OXFORDSHIRE COUNTY COUNCIL'S RESPONSE TO CONSULTATION ON THE FOLLOWING DEVELOPMENT PROPOSAL

Application no: 22/03873/F

Proposal: Installation and operation of a renewable energy generating station comprising ground-mounted photovoltaic solar arrays and battery-based electricity storage containers together with a switchgear container, inverter/transformer units, Site access, internal access tracks, security measures, access gates, other ancillary infrastructure and landscaping and biodiversity enhancements.

Location: Land North And Adjacent To Mill Lane, Stratton Audley

MSSP1362A: Stratton Court Barn, Bicester  
 Figure 14 - Magnetic Interpretation (Areas 2 (East) and 3)  
 1:1,500 @ A3  
 Copyright Magnitude Surveys Ltd 2022  
 Contains Ordnance Survey data © Crown Copyright and database right 2022

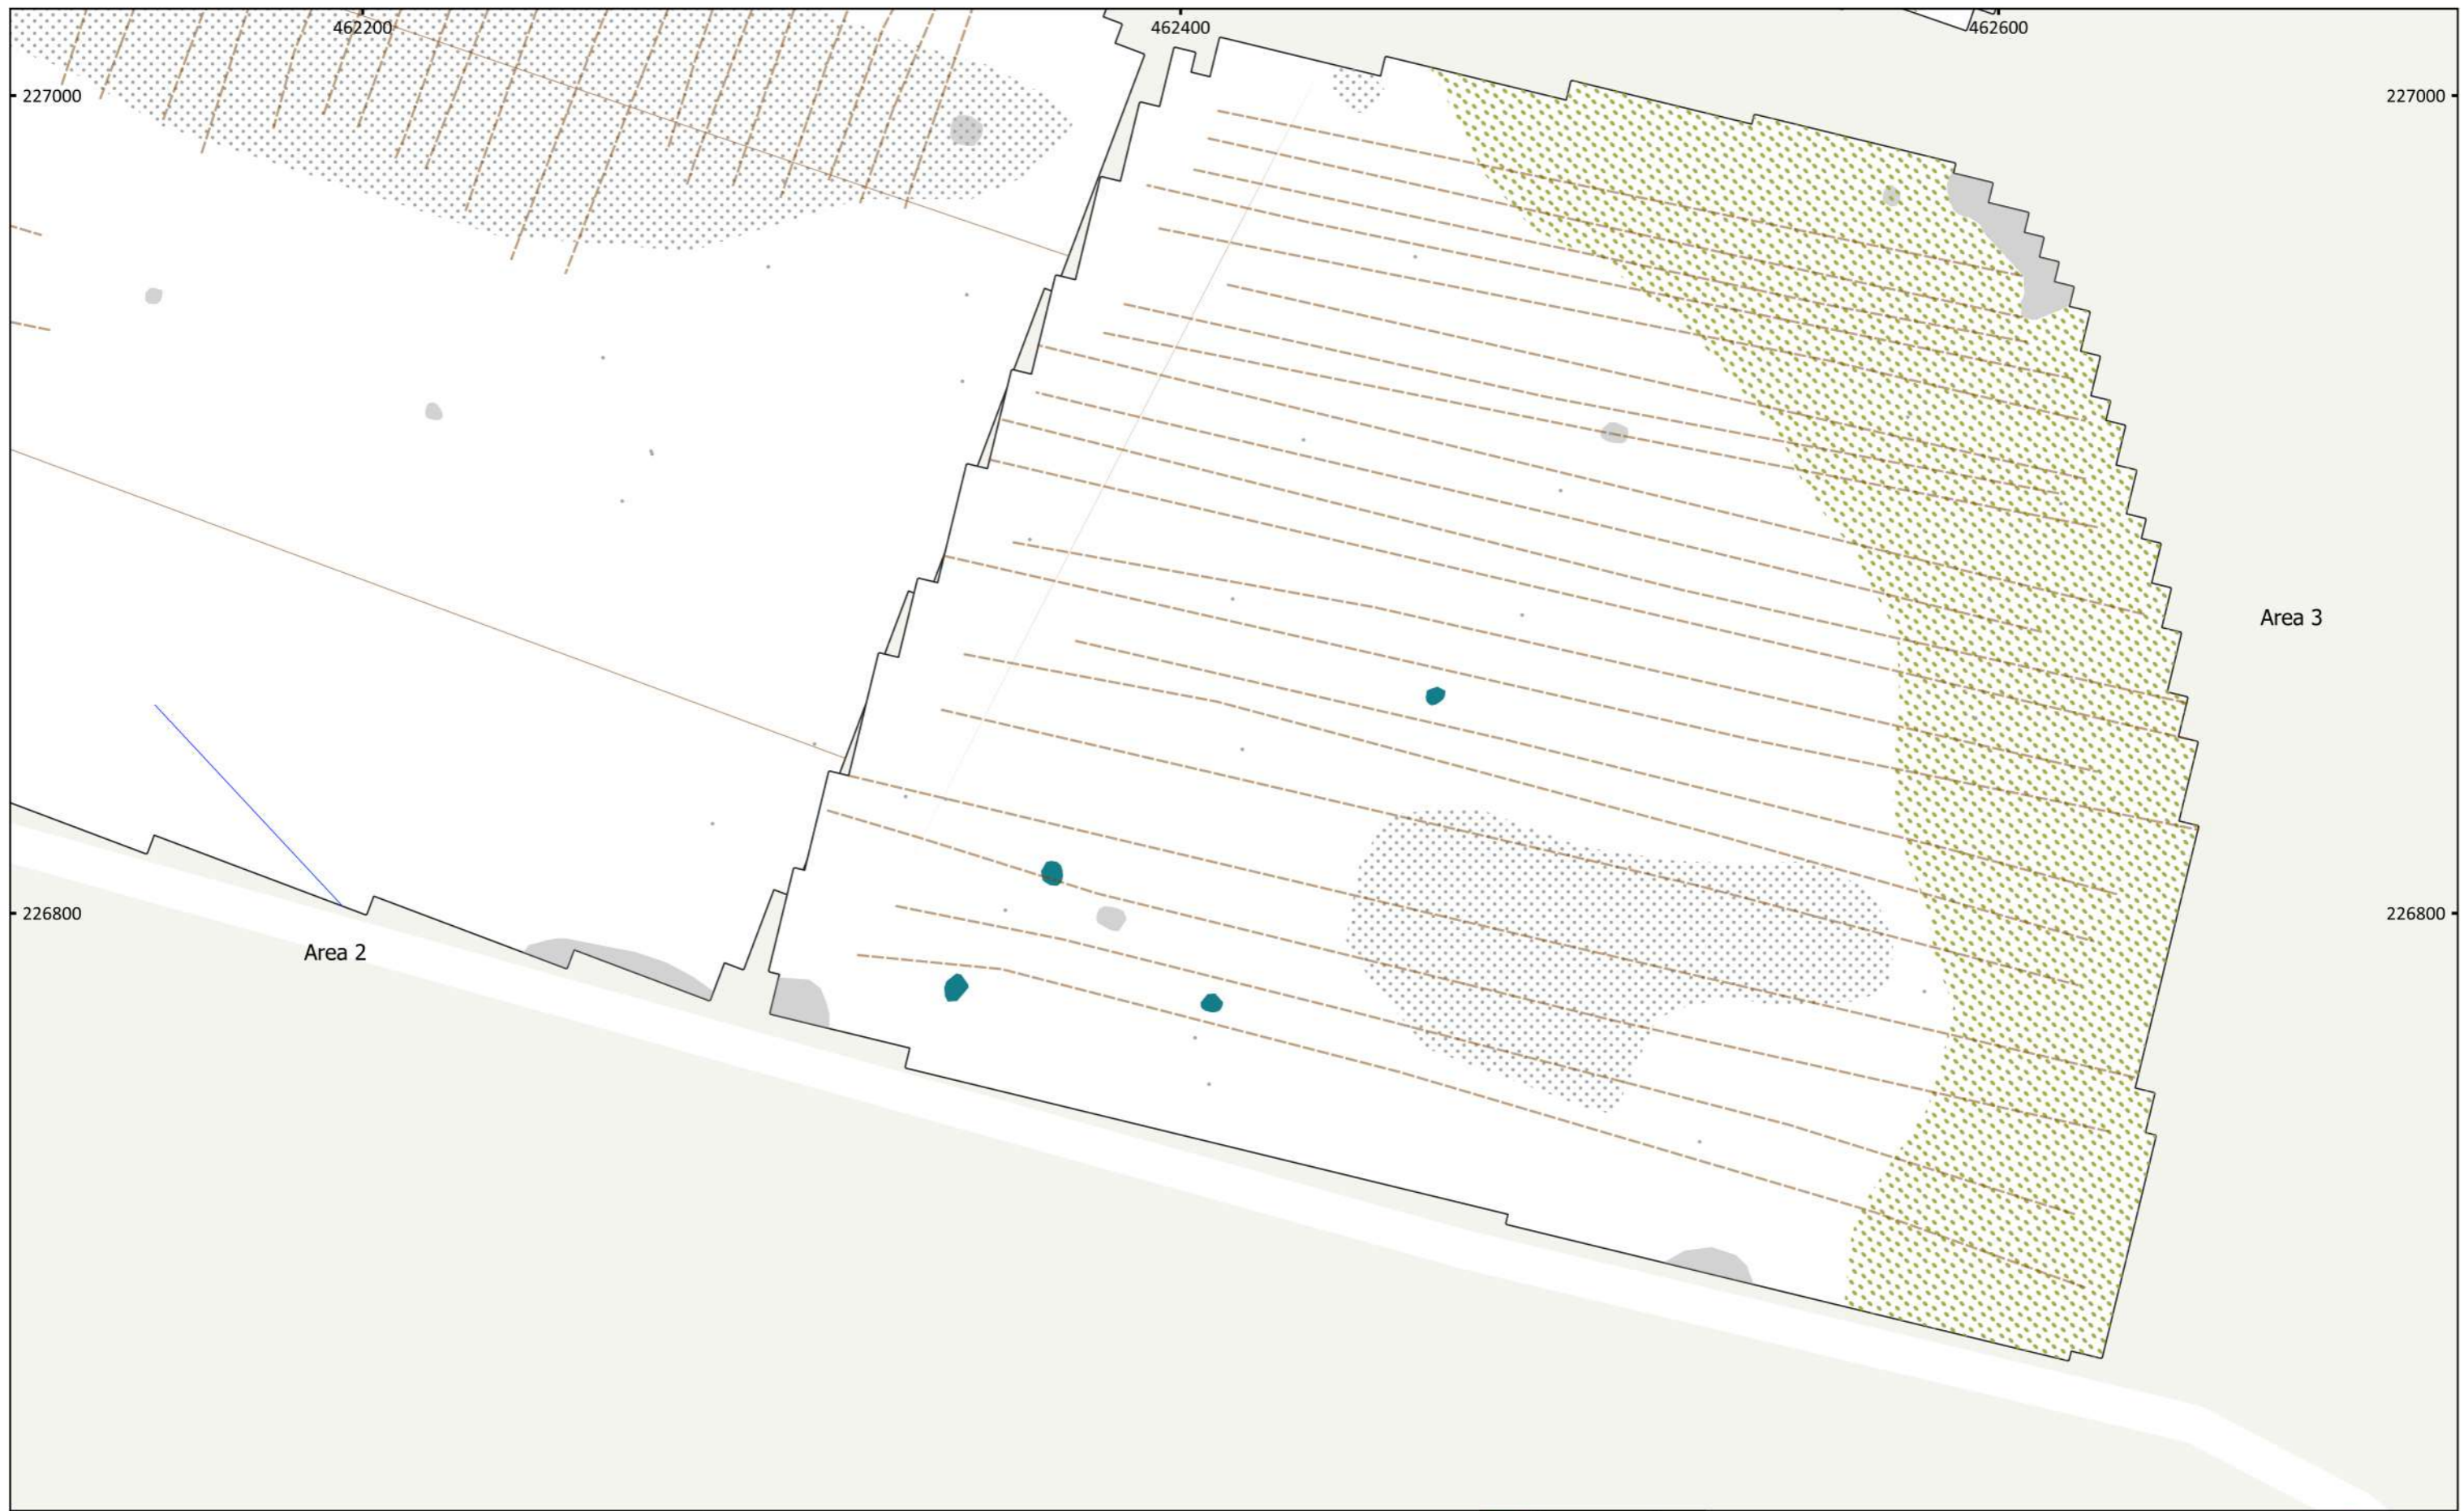
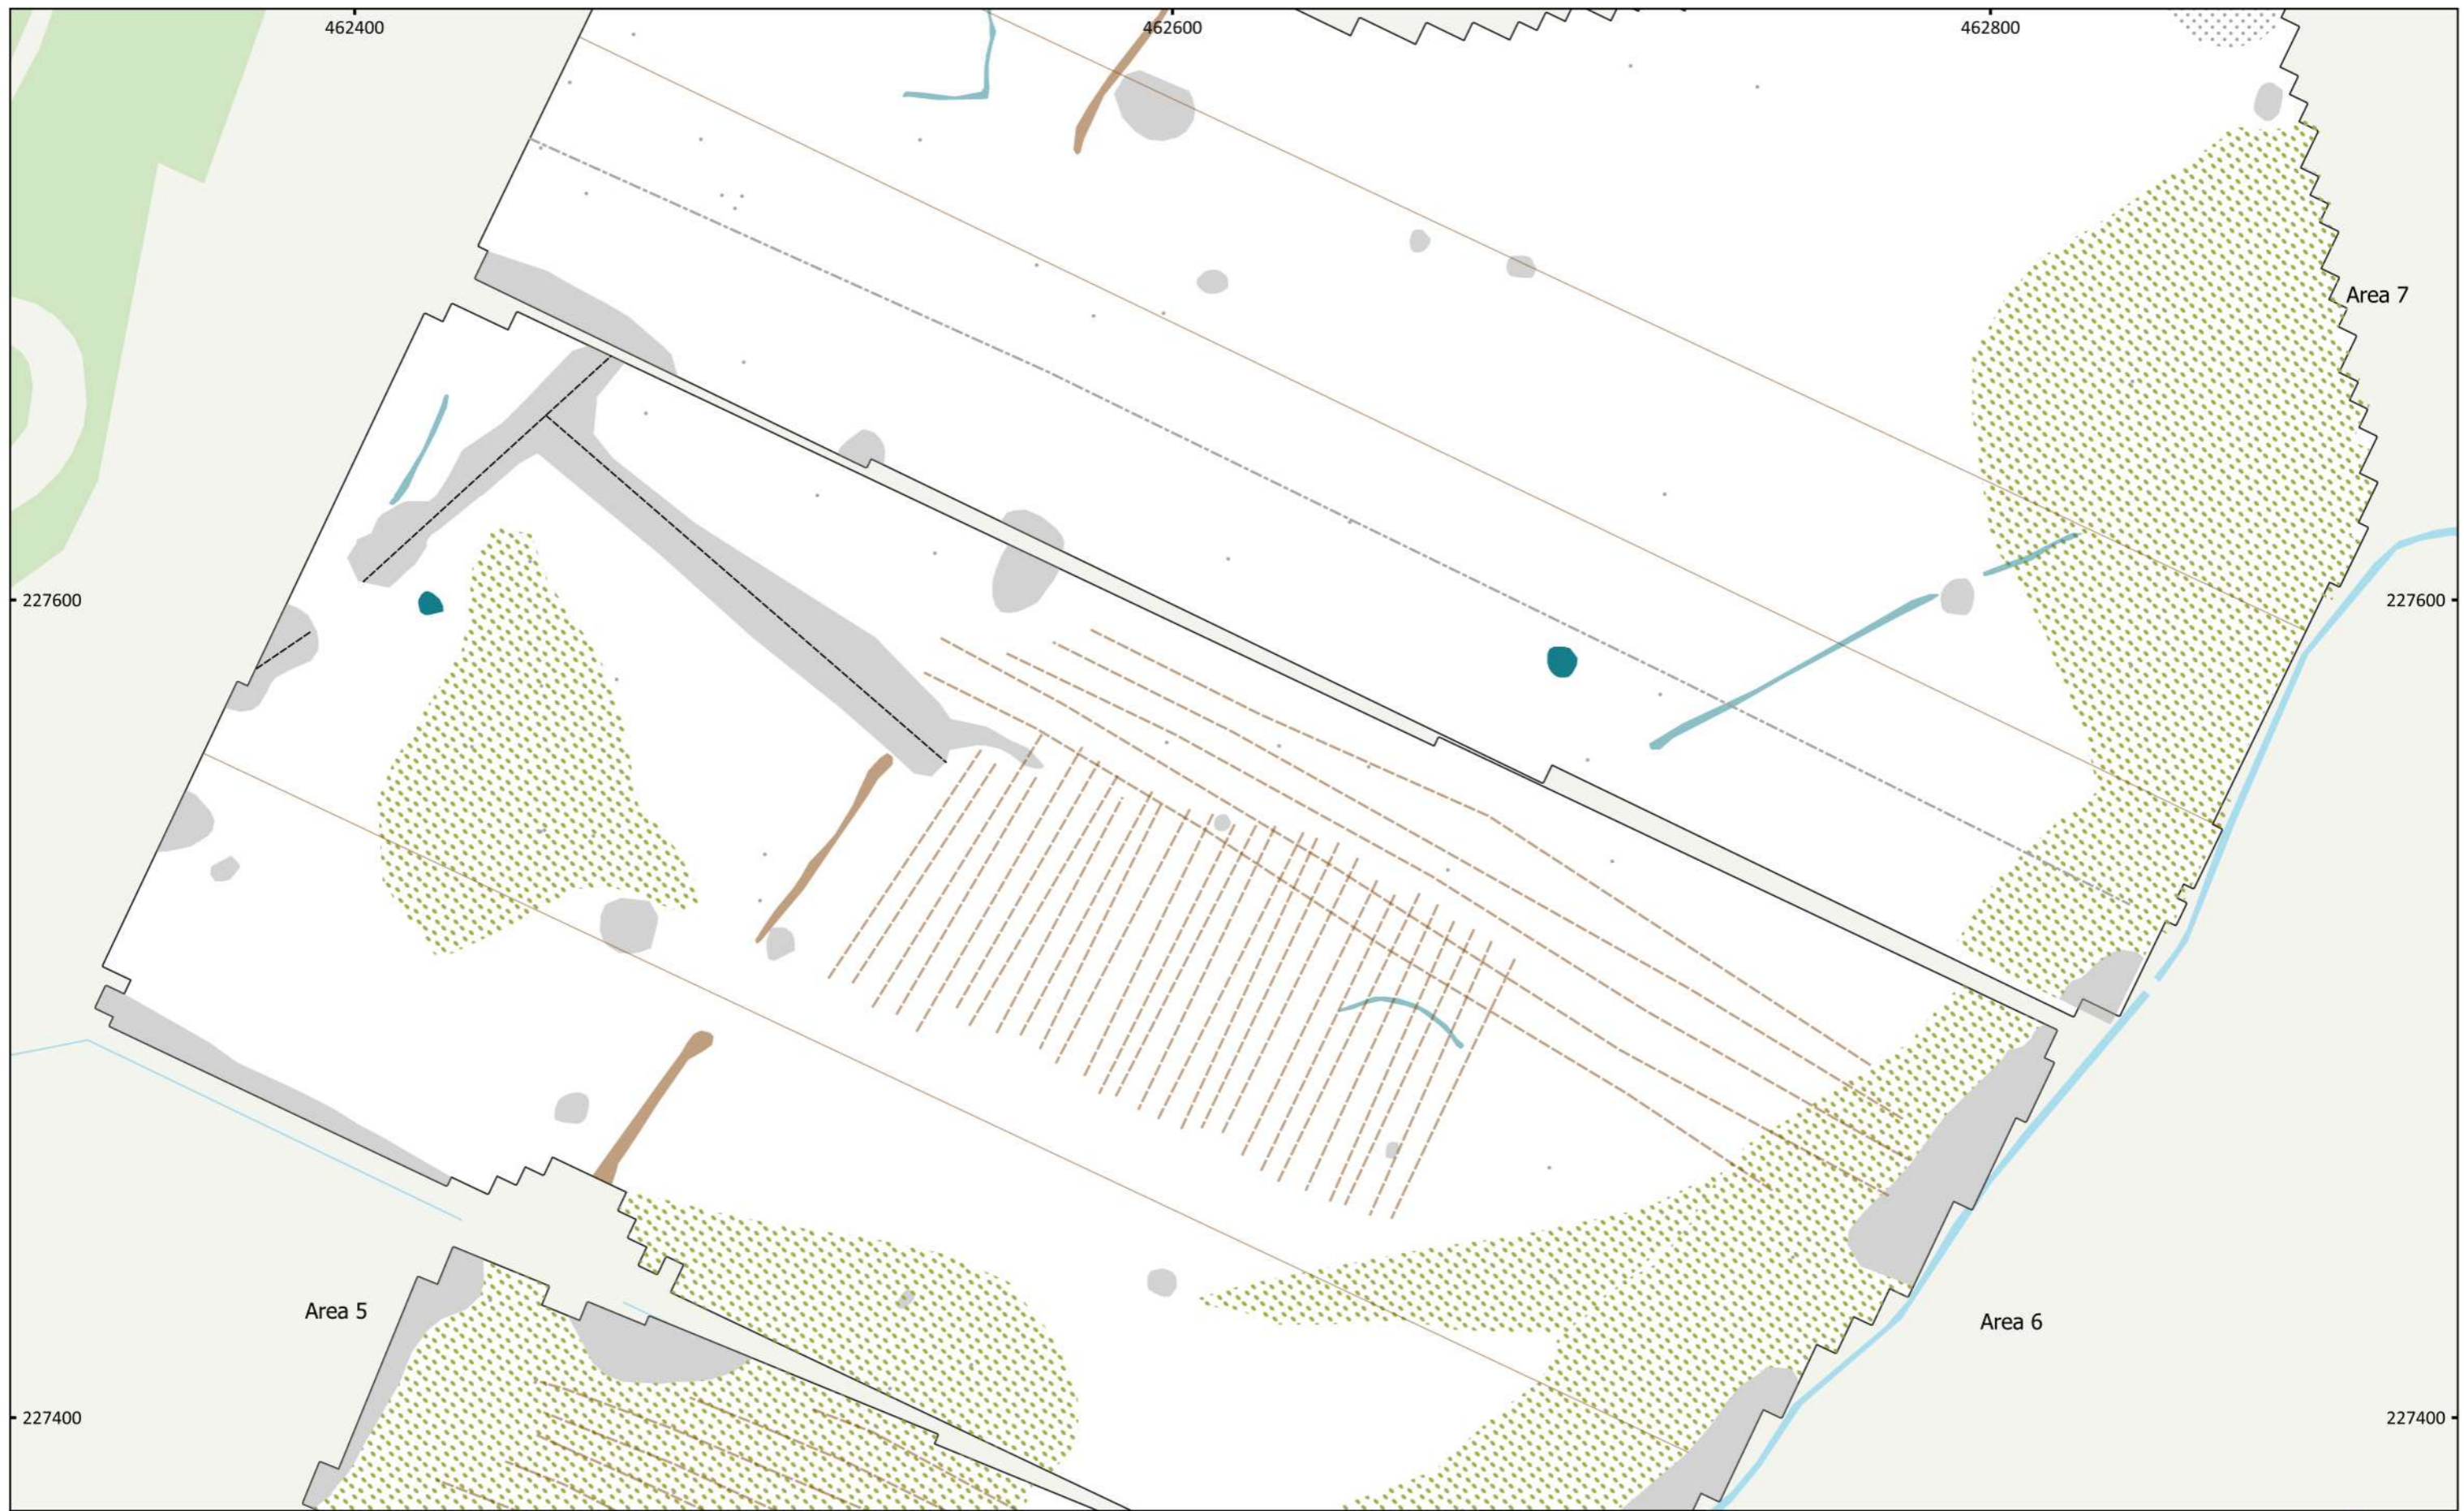
The geophysical survey and desk-based assessment carried out on the site have identified some areas of potential prehistoric activity. These will need to be investigated through a programme of pre-determination evaluation.

The site lies in an area of archaeological interest and potential, as outlined in the submitted archaeological desk-based assessment and geophysical survey report. The geophysical survey and ADBA have identified areas with potential prehistoric burning activity, and other undetermined features. These should be investigated through a trenched evaluation prior to the determination of the application.

In accordance with the National Planning Policy Framework (NPPF 2021) paragraph 194, we would therefore recommend that, prior to the determination of this application the applicant should therefore be responsible for the implementation of an archaeological field evaluation.
